Tween Bridge Solar Farm

9.10 Statement of Common Ground with National Highways

Document Reference: 9.10

Statement of Common Ground

Document Ref: 6.4.6.4 AFPP Reg: 5(2)(a) Revision: 2
 PINS Number: EN010148 Drawing Status: Final
 Drawn: LAB Checked: HS Approved: KC Date: 17/04/2026

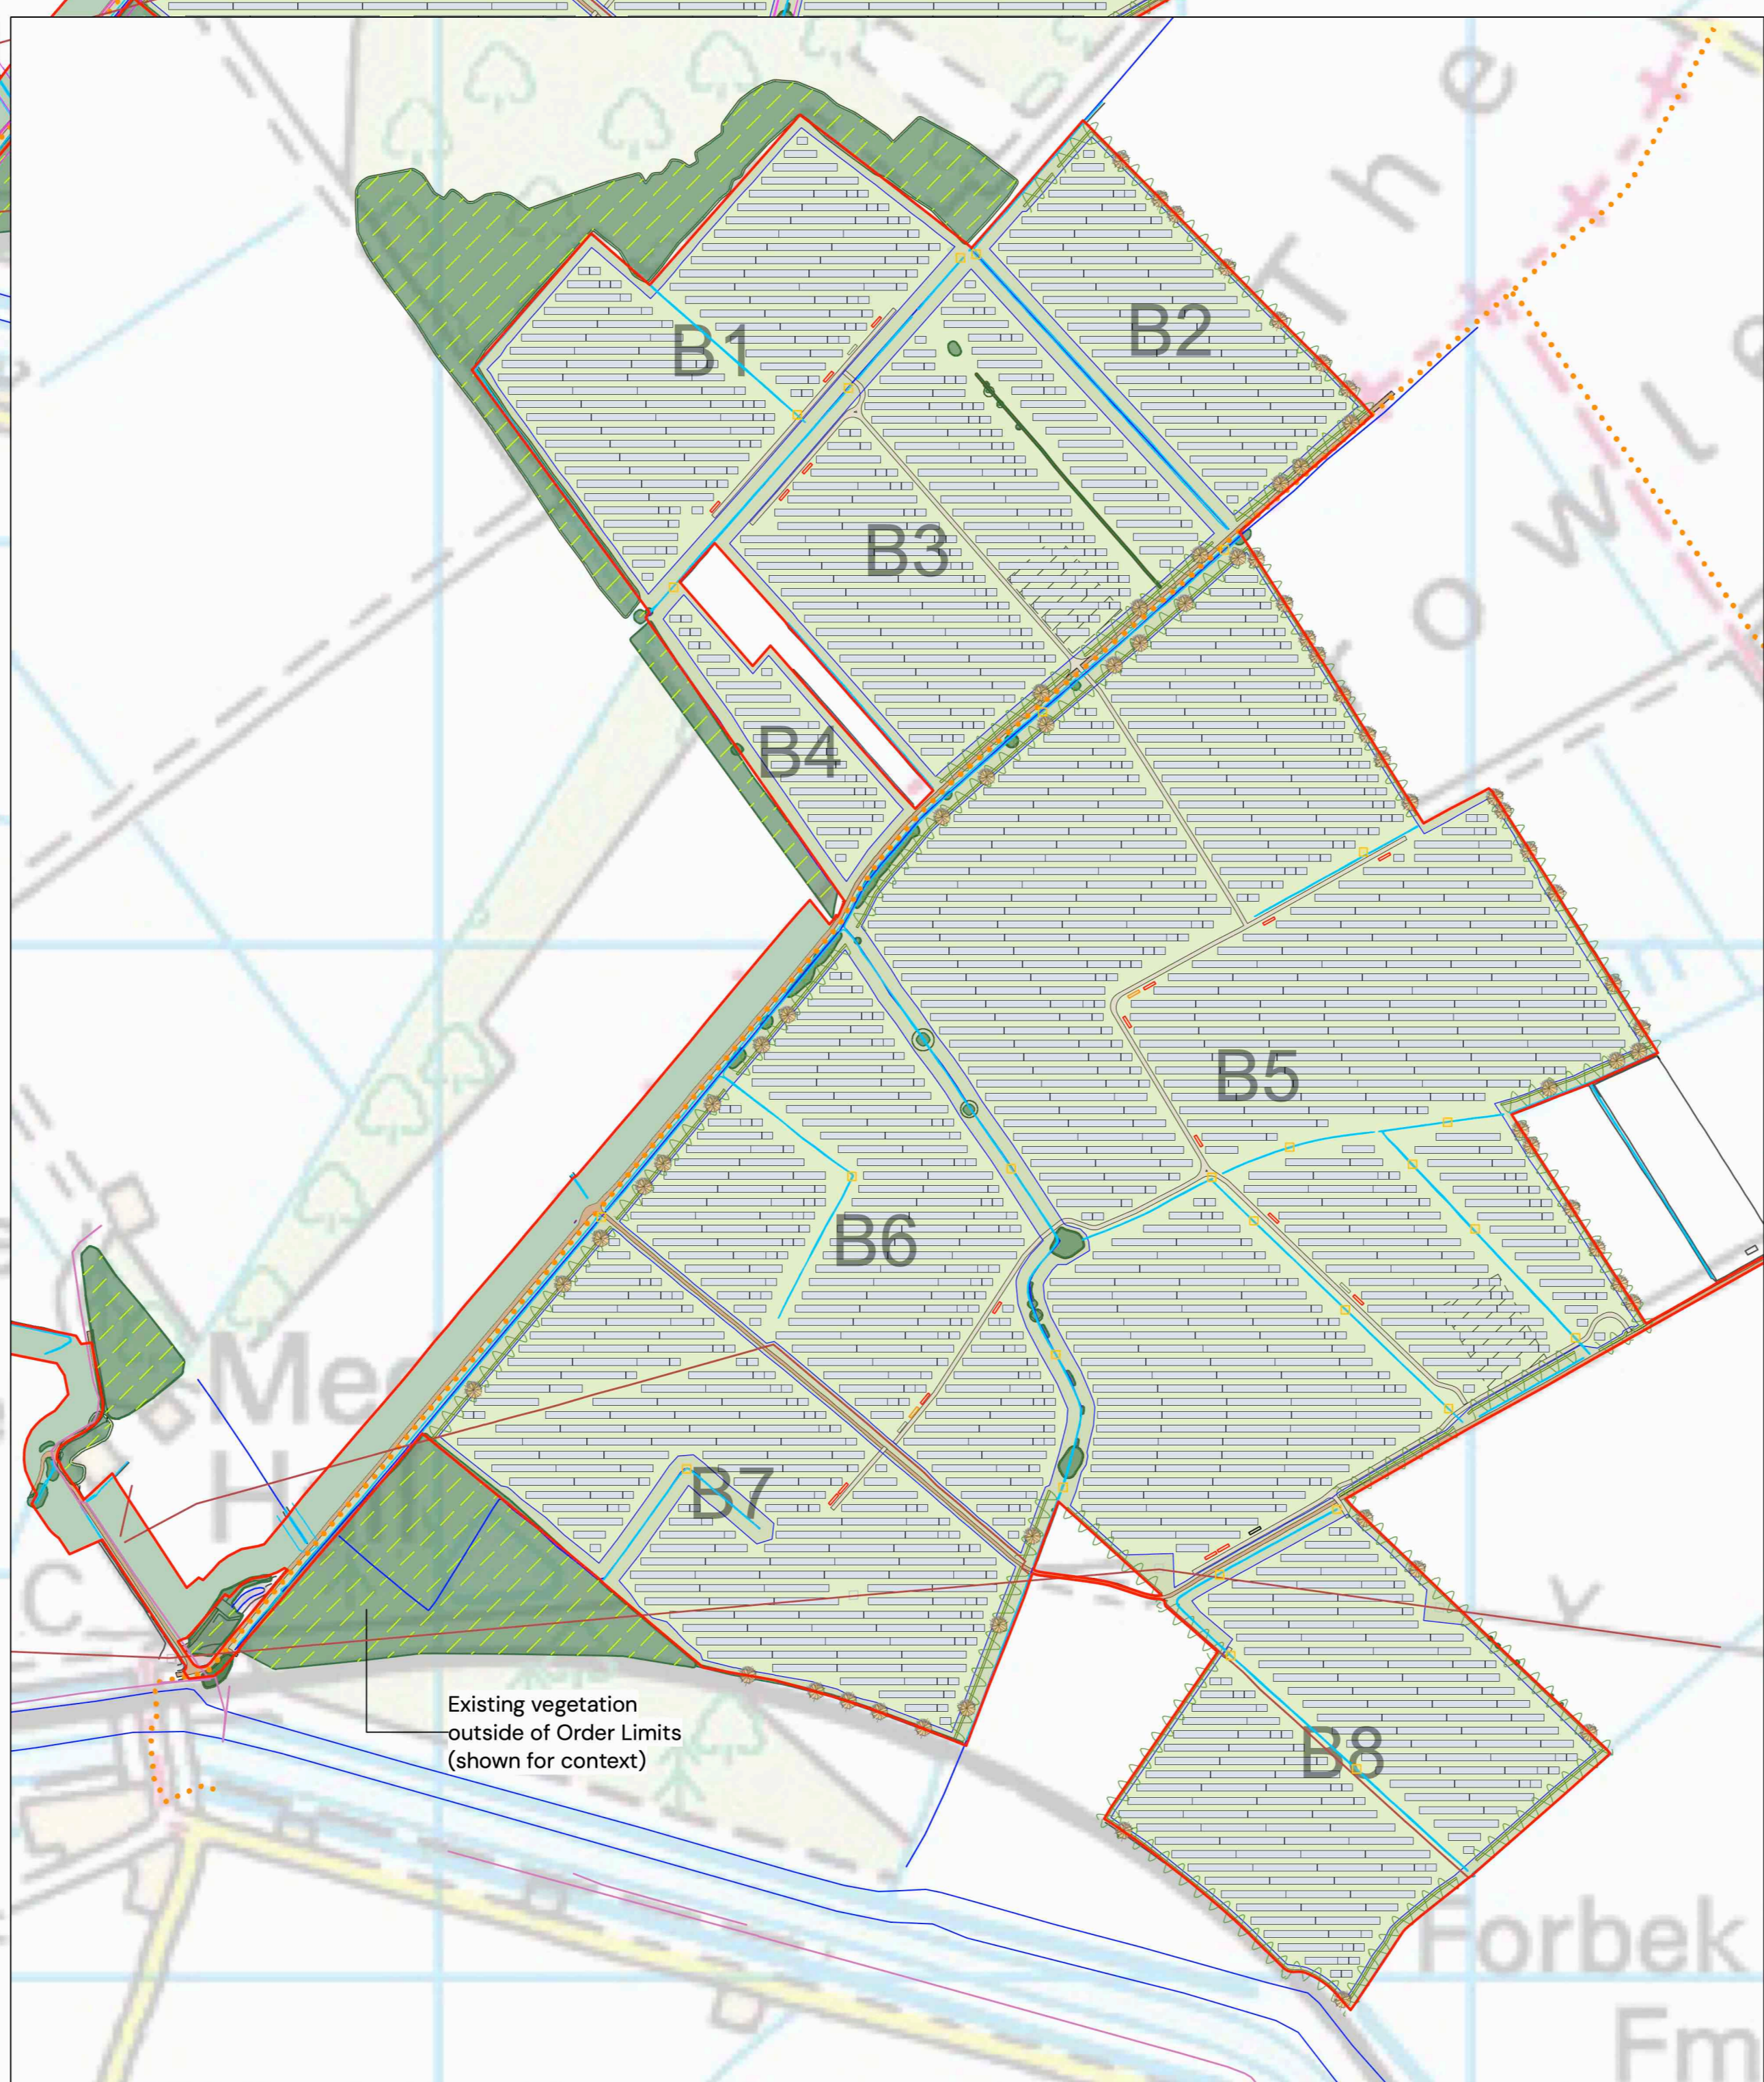
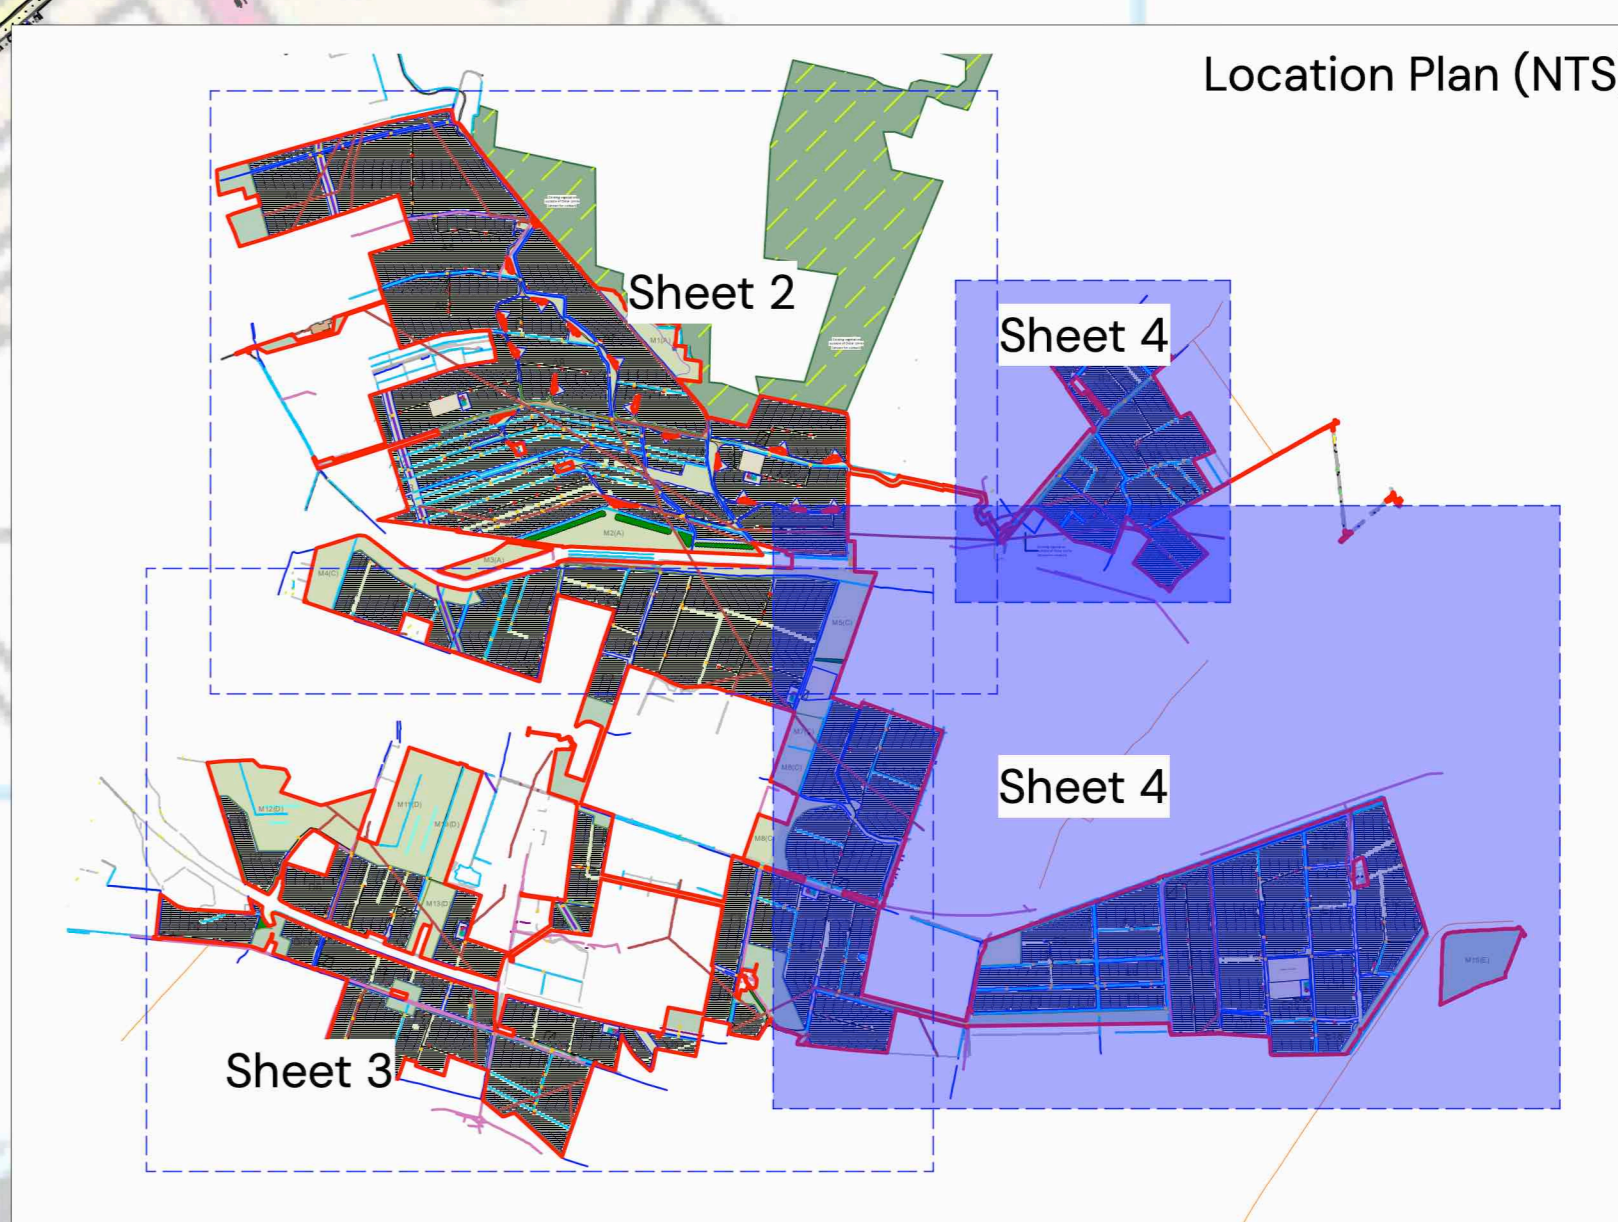
comments which NH has on the same as part of its ongoing engagement.	
7	<p>Glint and Glare Assessments [APP-122 and REP1-O25] and Outline Landscape Ecological Management Plan [REP1-O34]</p>	<p>NH notes that no dedicated mitigation is proposed in respect of glint and glare effects. The residual effects of glint and glare can have substantial impact on the safety of road users and it is of critical importance to NH that the mitigation applied in the Landscape Ecological Management Plan is satisfactory and suitably maintained to enable establishment.</p> <p>The Applicant is also proposing additional planting in existing planting areas in close proximity to the SRN, which would require the approval of NH's environmental team due to the sensitive ecosystem at these locations.</p> <p>NH therefore requires that Requirement 8 of the draft DCO is amended to include NH as an approving body for the detailed Landscape Ecological Management Plan with regard to the specific elements relevant to the SRN (refer to point 9 below).</p>	<p>In the Glint and Glare assessments, mitigation is only required where a high impact is predicted on a road. Environmental Statement Appendices 16.1 and 16.2 [APP-122 and Document Reference 6.3.16.2 Revision 2] REP1-O25 and REP1-O26 conclude that a moderate impact is predicted on separate 0.2km and 1.6km sections of the M180, and a 0.1km section of the A18. On the basis that the predicted impact is moderate, mitigation is not deemed to be required. However, planting has nonetheless been proposed as part of the Scheme to reduce the effect further over time.</p> <p>The Applicant agrees that appropriate provision must be made for the ongoing management and maintenance of planting. The proposed management prescriptions for retained and proposed planting are set out in Table 4-1 of the Outline Landscape Ecological Management Plan</p>	<p>Under discussion</p>

<p>[Document Reference 7.6 Revision 2CR1-021] submitted at Deadline 1.</p> <p>The location of the proposed mitigation planting to screen views of the fencing and panels and in turn to mitigate glint and glare effects are set out on the drawings at ES Figure 6.4 Landscape and Visual Mitigation Strategy [Document Reference 6.4.6.4 Revision 24] submitted at Deadline 1. A Landscape and Ecology Plan submitted for approval under Requirement 8 of the draft DCO [Document Reference 3.1 Revision 46] must be substantially in accordance with the Landscape and Visual Mitigation Strategy, therefore ensuring the proposed mitigation is legally secured.</p> <p>The Applicant considers that the relevant local planning authority is the appropriate consent granting body in respect of the written Landscape and Ecology Management Plan submitted under Requirement 8.</p> <p>However, the Applicant amended the draft Development Consent Order (DCO) at Deadline 1 [REPI-004] to</p>
